032-I-042

Marge Schmuckal - Re: Fwd: FW: Decibel dBA levels at closest property line for rooftop equipment

From: Marge Schmuckal
To: Helen Donaldson
Date: 3/19/2014 4:02 PM
Subject: Hotel dBAs

Drawing Number  
**M10.8**

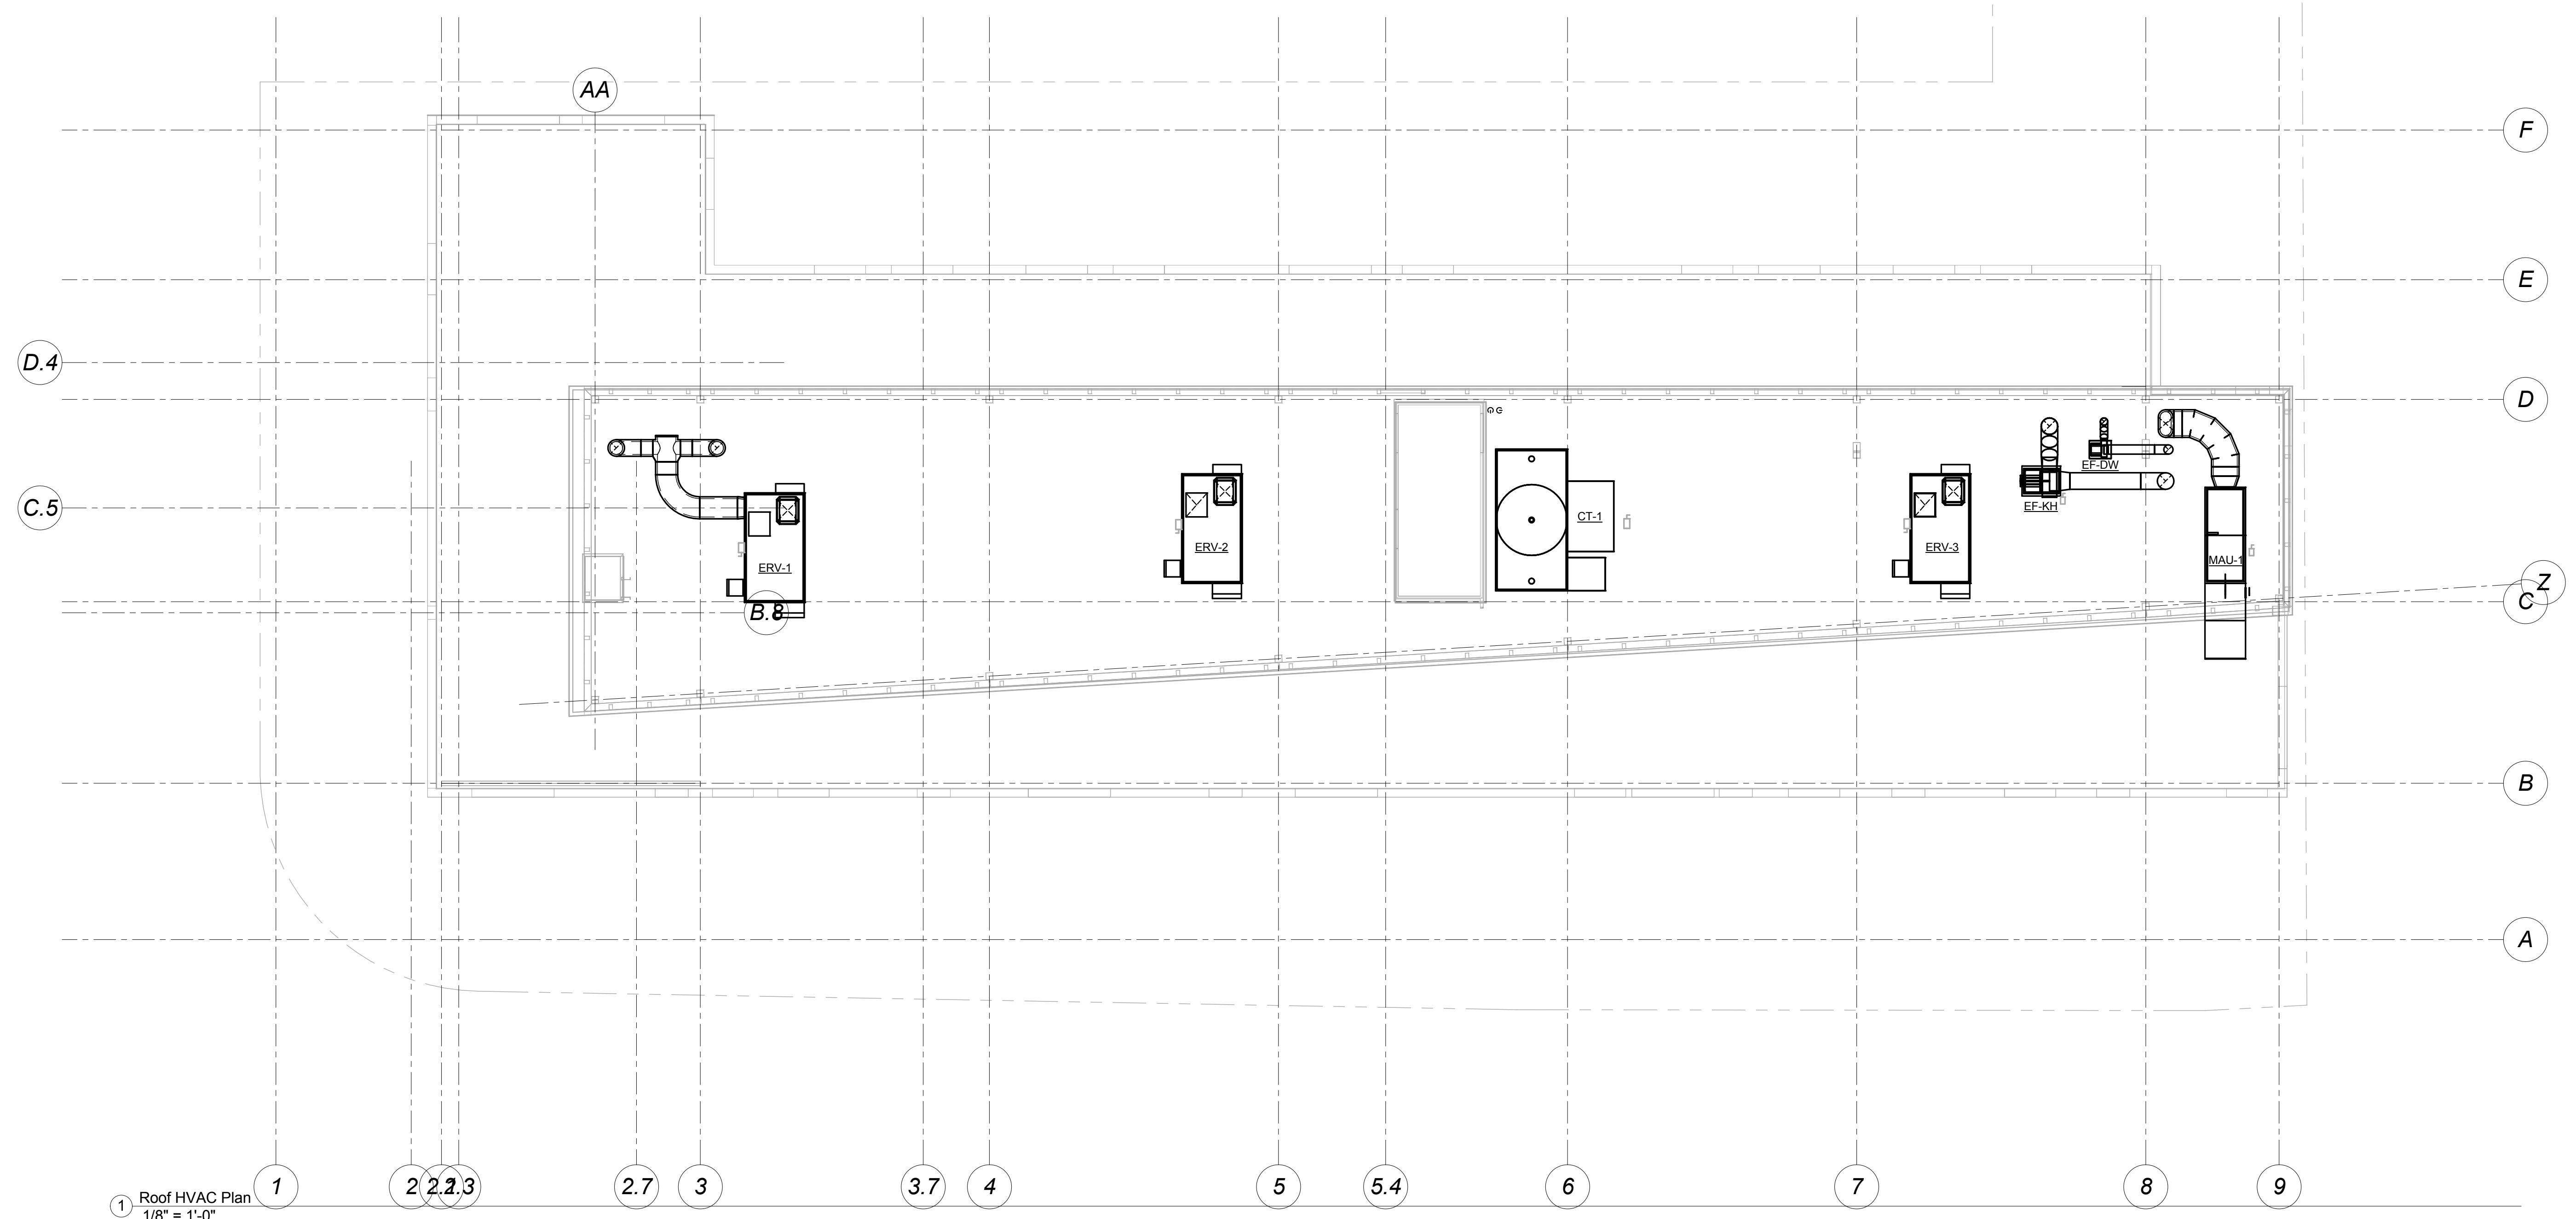
Greg, I have taken the rated dBA for each piece of equipment and calculated the dBA levels at the closest property line. As you can see, all equipment falls under the 55 to 60 dBA constraints of the B-3 zone.
Tim

Unit	Rated dBA	Rated dBA Dist. (ft)	dBa @ 40'
ERV1	60	5	44
ERV2	60	5	44
ERV3	60	5	44
Split Unit Condensor 1	53	5	38
Split Unit Condensor 2	53	5	38
Split Unit Condensor 3	53	5	38
Cogen Microturbine	56	3	35
Makeup Air Unit	77	2	53
Exhaust Fan D/W	60	3	39
Cooling Tower	67	5	52

* 40' represents the distance of the closest property line (North line at CMP)

What I received shows different information. Greg Staed that the C=Gen decibel rating is 54-56 which meets the B-3 external effects. However, the rest of what he sent shows perhaps other equipment that list overall dBAs of 67, 63, 68, & 62. the B-3 maximizes 60 during day time and 55 during night time. That could be alright if the readings were done right at the unit. The readings may be different at the property lines. I would need that to be explained.

Hi Nell,
this information shows that The equipment would fall under the required maximum dBAs for the B-3 zone. this is not a substitute for the required HVAC permits that are required.
Marge
